## **RE: Pamela Road Extension/Subdivision Amendments**

### **Staff Review Comments on Level III Subdivision Amendments**

### Preliminary Staff Comments on Level II Site Plan/14-403 Street Extension

DATE: AUGUST 2009
 CITY OF PORTLAND, MAINE
 TECHNICAL STANDARDS MANUAL
 SANITARY SEWER AND STORM DRAIN DESIGN STANDARDS
 SECTION II
4' GRANITE HEADSTONE FOR CATCH BASIN INLET
 FIGURE: II-11

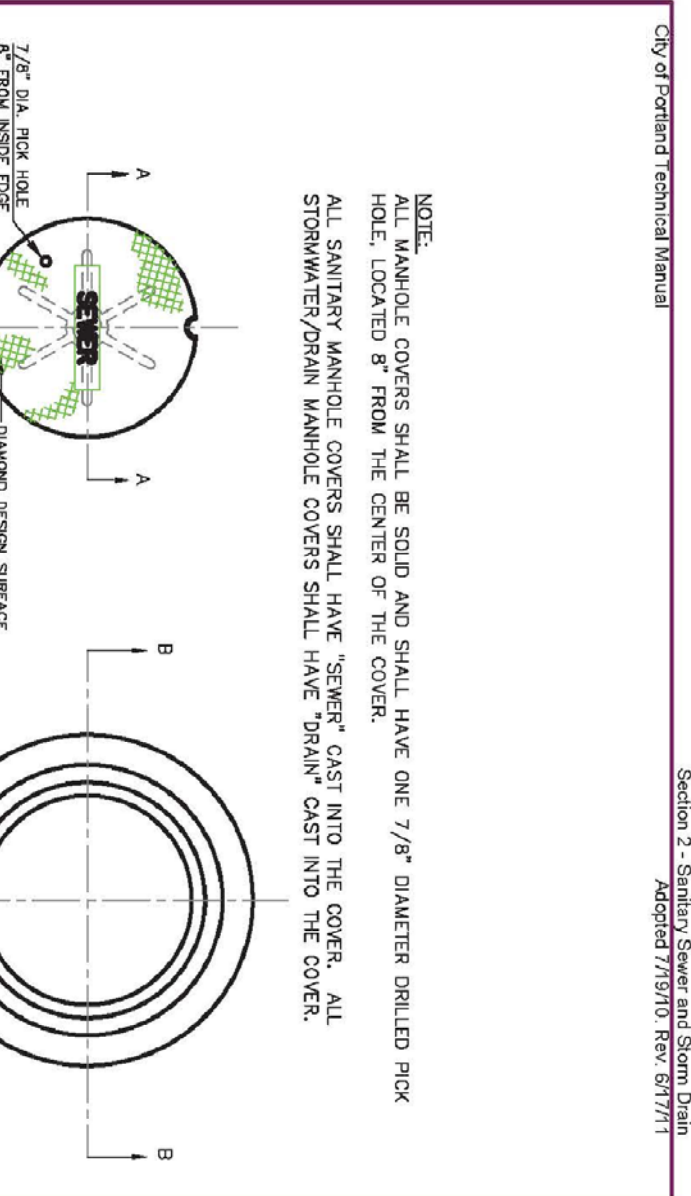
- The Applicant should provide the following details in accordance with the City of Portland Technical Manual for work within the City Right-of-Way:
  - 4' Granite Headstone for Catch Basin Inlet per Figure II-11. **The detail has been provided. See sheet 9 of 12.**

CONSTRUCTION DETAILS - SHEET 2

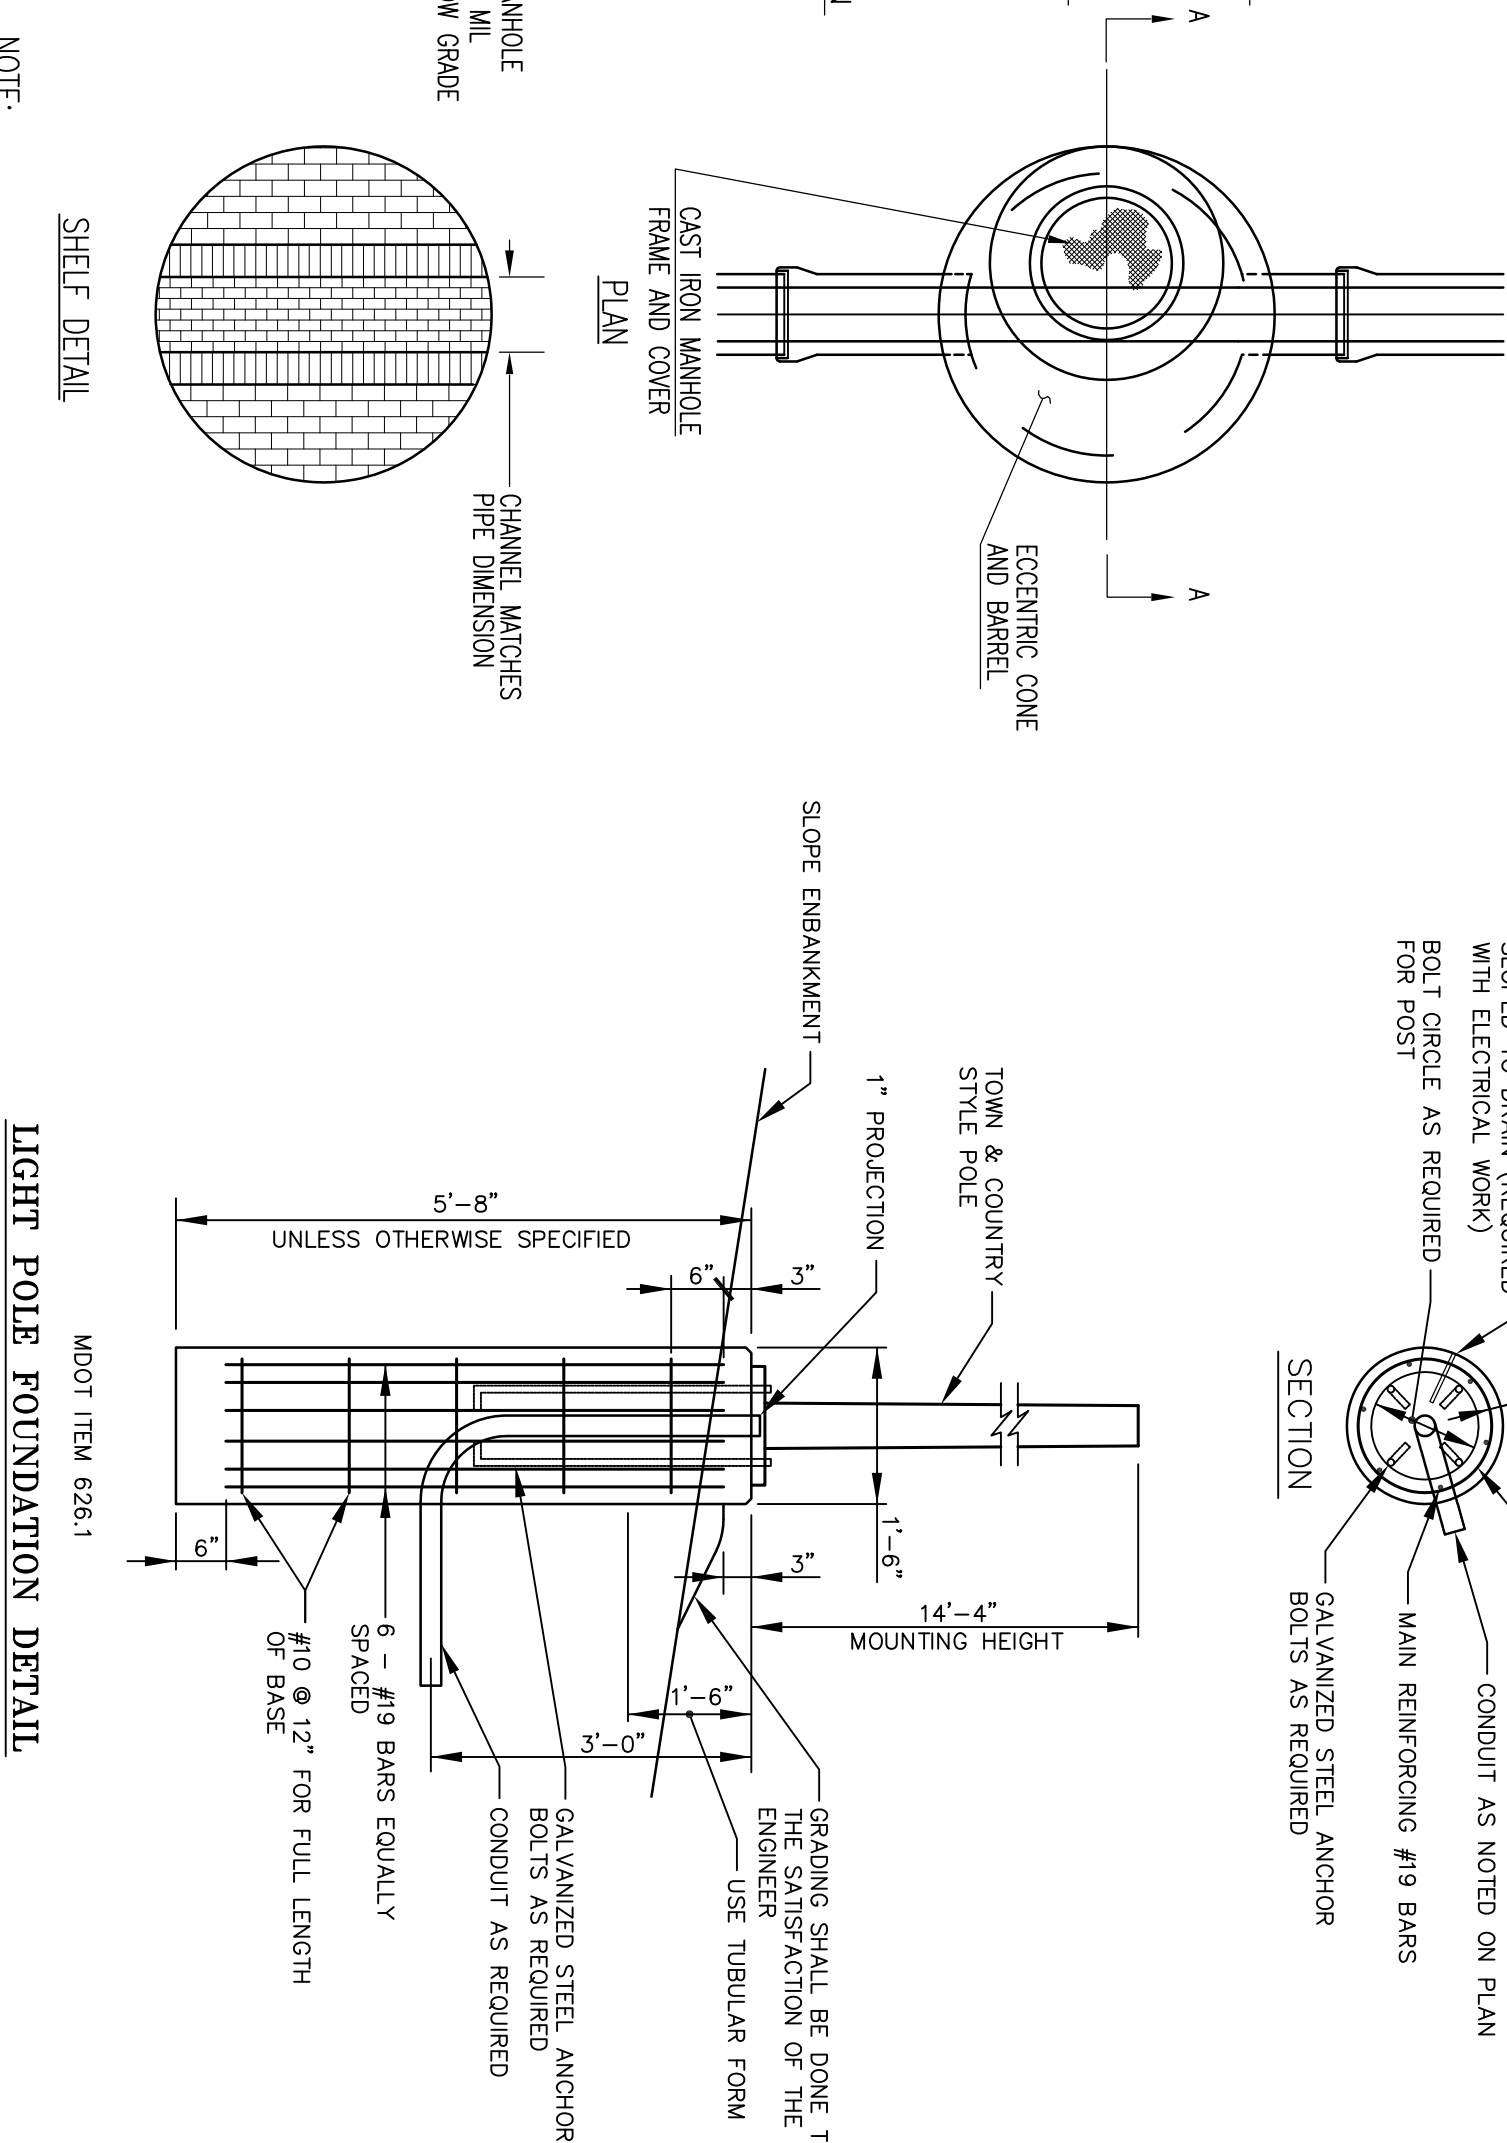
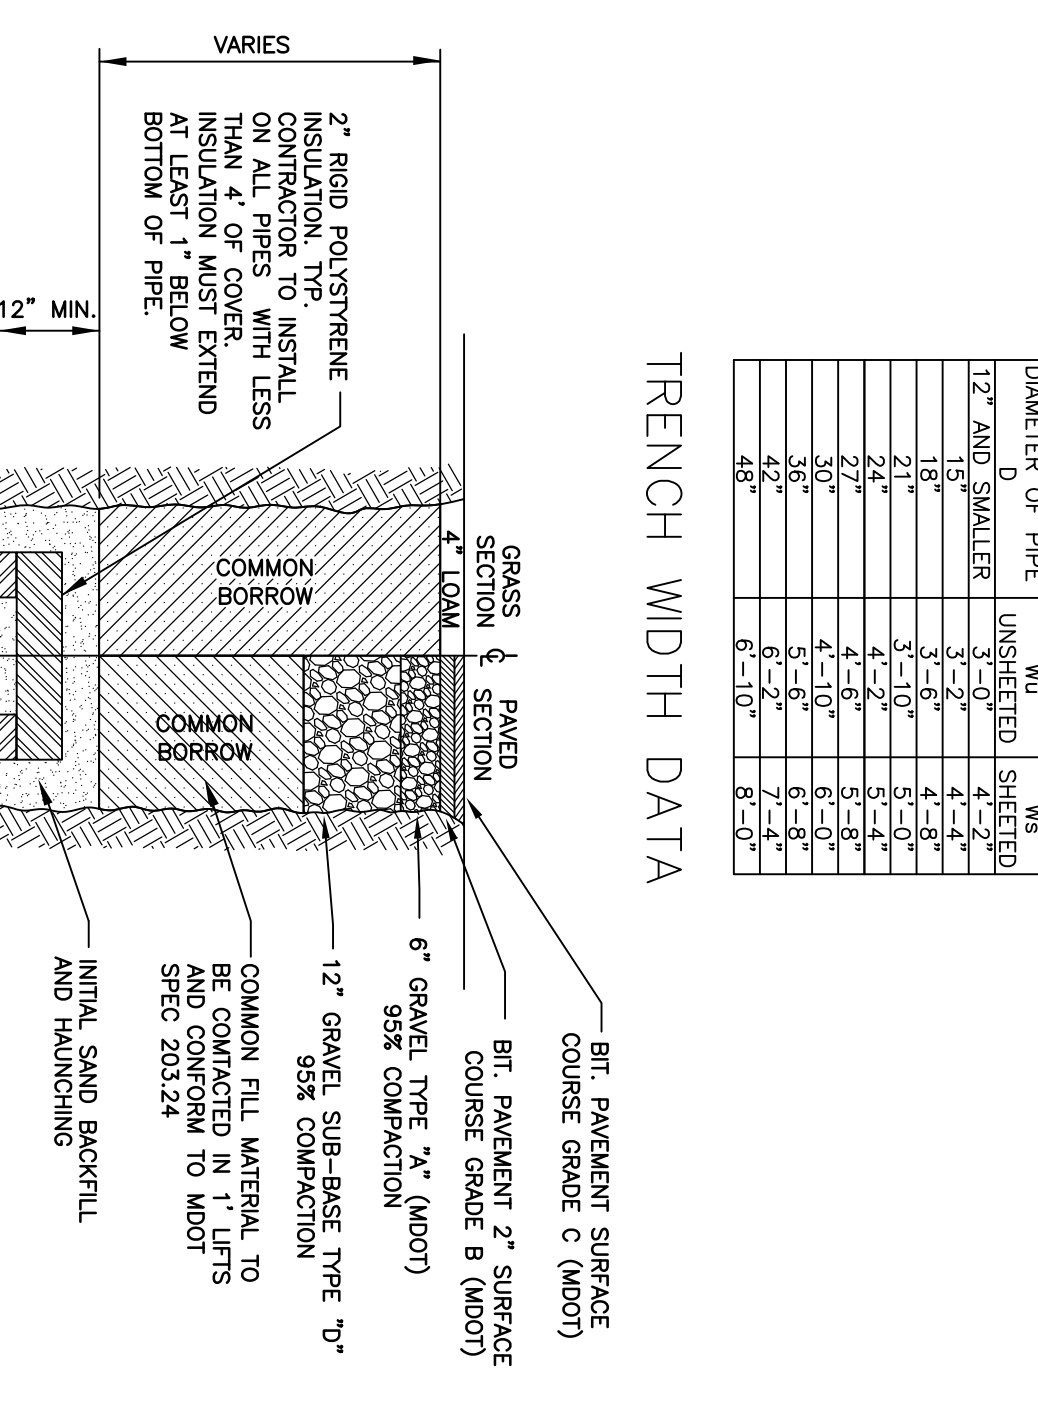
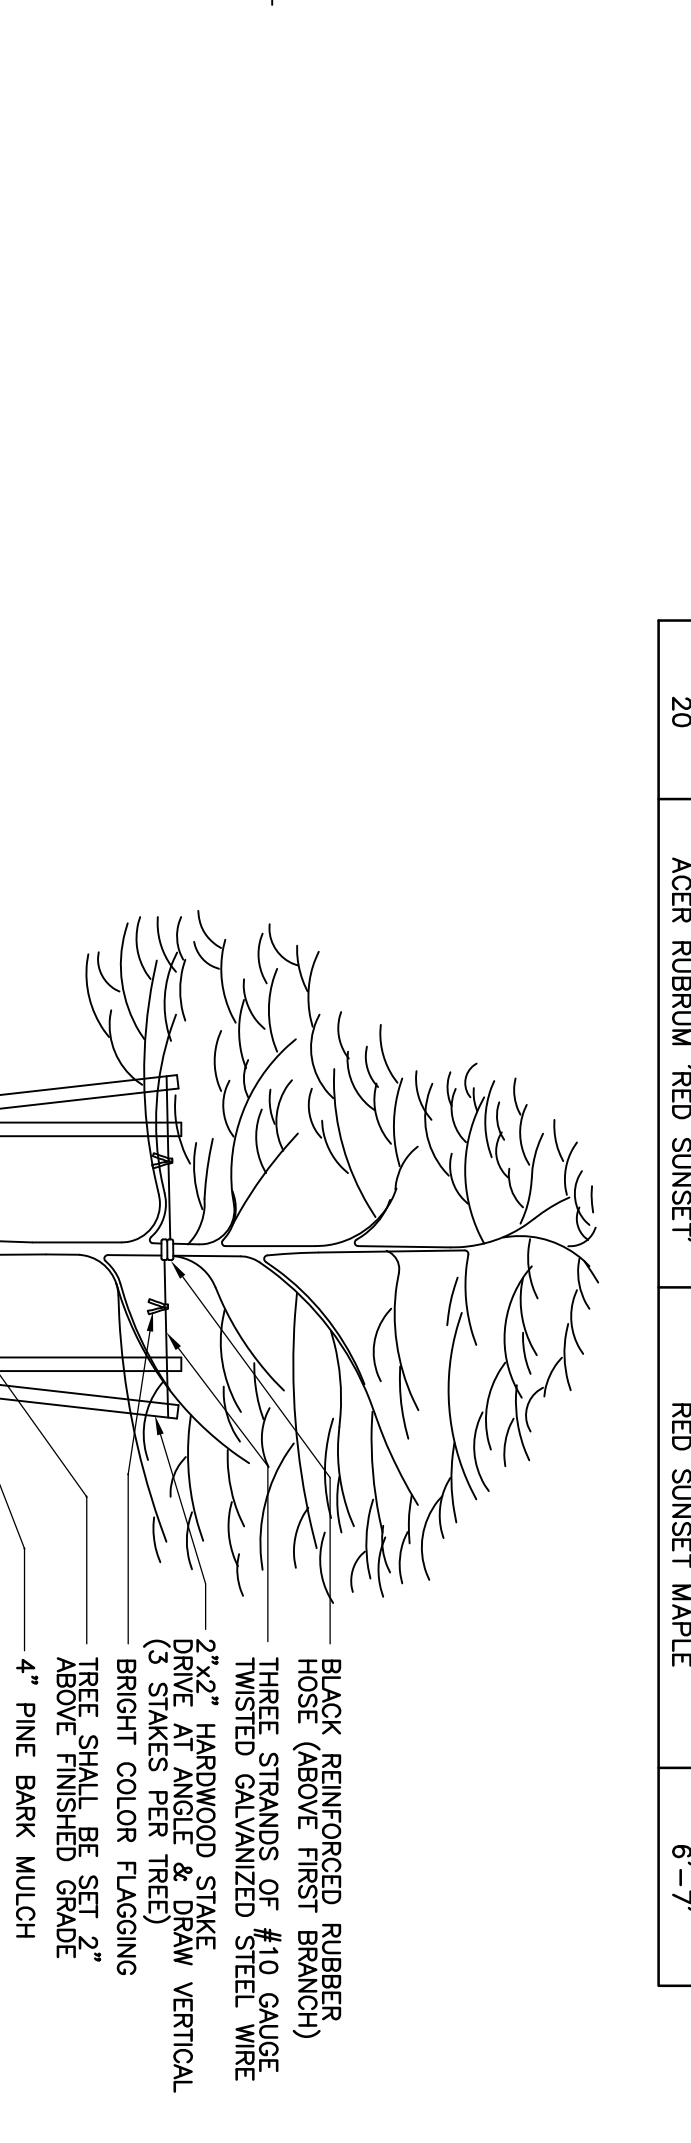
Per the city’s site plan ordinance and as prescribed in Section 4 of the city’s Technical Manual, two street trees are required per lot. These should be added to the site plan. It is noted that the site plan shows a “proposed tree line.” If this is intended to meet the street tree requirement, notes regarding its protection should be added to both the site plan and subdivision plats. **Street trees are now proposed, two per lot. See sheet 4 of 12.**
